RE: Sevilla @ Andalusia - (File: F11D015C)
Drainage Management Plan, Engineer's Stamp Date 12-19-2014
Grading and Drainage Plans, Engineer's Stamp Date 12-18-2014

Based upon the information provided in your submittals received 12-19-14, the above referenced submittals cannot be approved Preliminary Plat and Site Plan for Subdivision action by the DRB until the following comments are addressed.

**EXHIBIT 3**  
**DEVELOPED BASINS MAP**

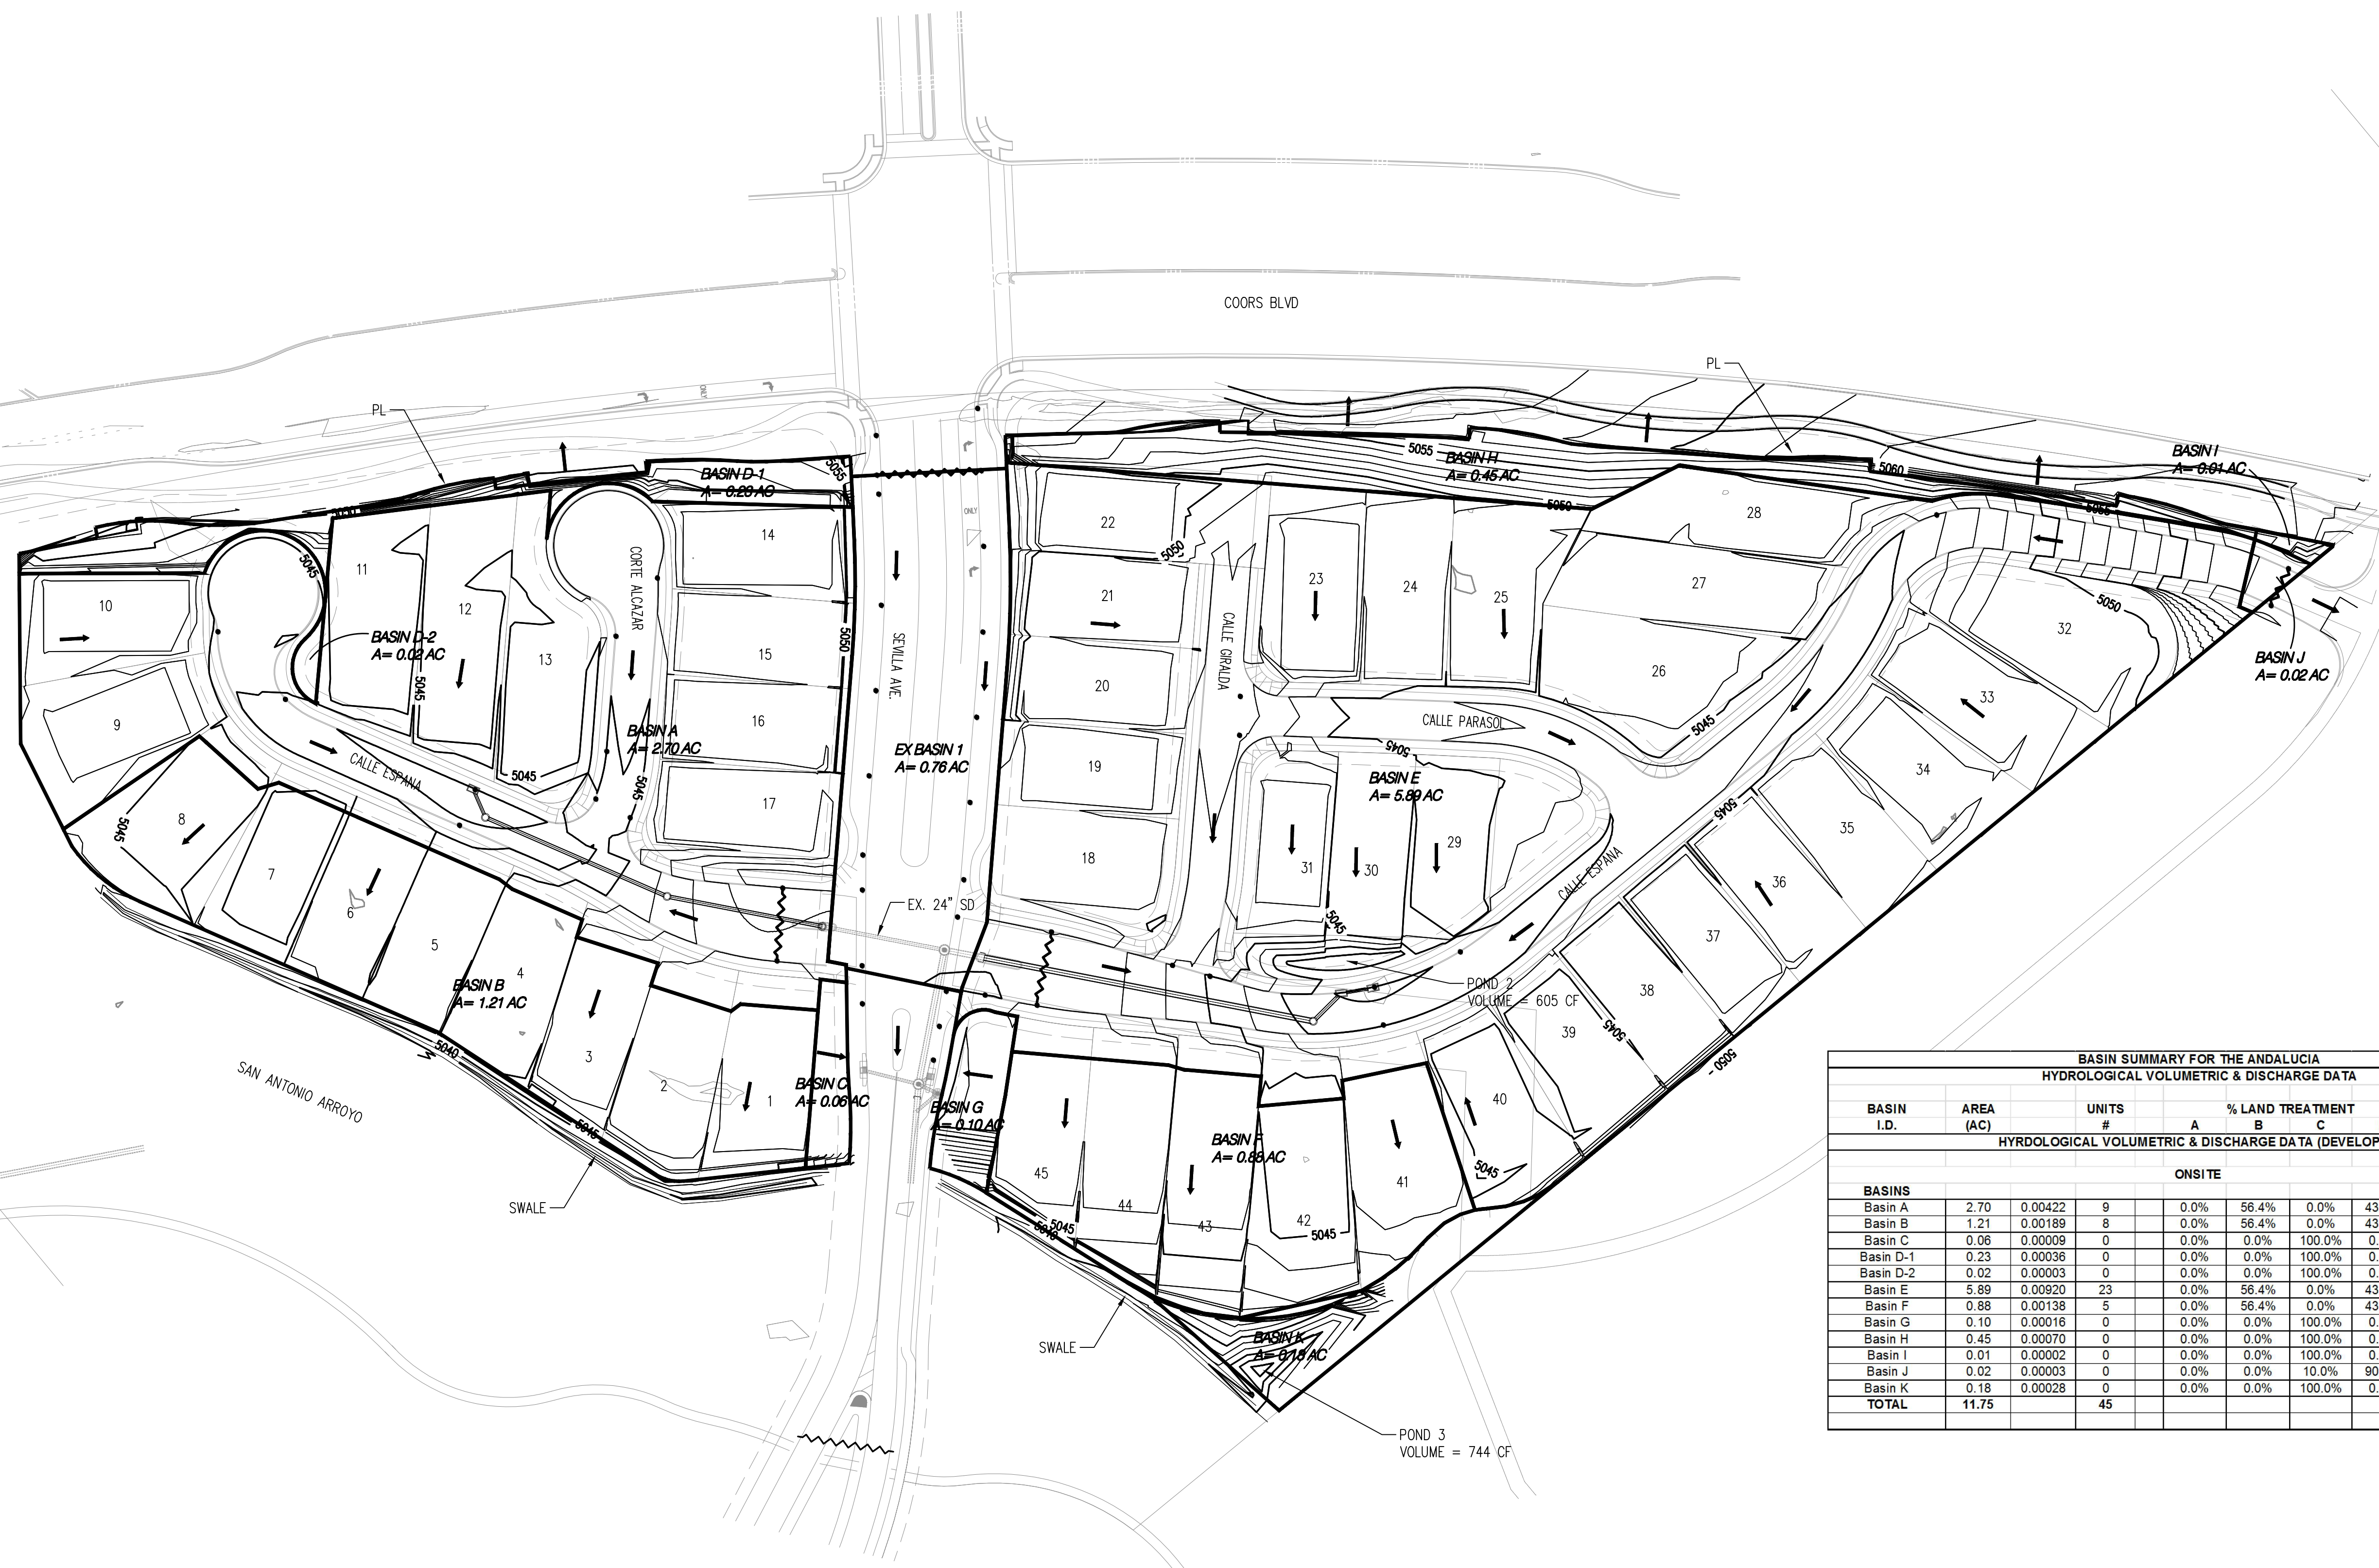
4. According to report, portions of Existing Basin 1 are conveyed to separate low points. Therefore, Existing Basin 1 should be divided accordingly to reflect this.

6. Adjust basin boundaries so that water blocks in Calle Espana coincide with basin boundaries.
7. Show an existing basin east of Existing Basin 1? Report and calculations should show that the 36" existing Storm drain has the capacity to convey the developed flows to its discharge location. What offsite basins contribute to flows in the existing 36" Storm Drain?

8. The contours, elevations and line work showing Coors Blvd, the curb and gutter are unclear.
9. Do flows on East side of Coors (in meandering sidewalk area) drain to this site? Particularly north of Sevilla Ave? The developed basin map shows flow arrows pointing west, but the contours do not support this. There seems to be some ponding in this area. Where is the R.O.W.? Where is the property line? How does this area drain?
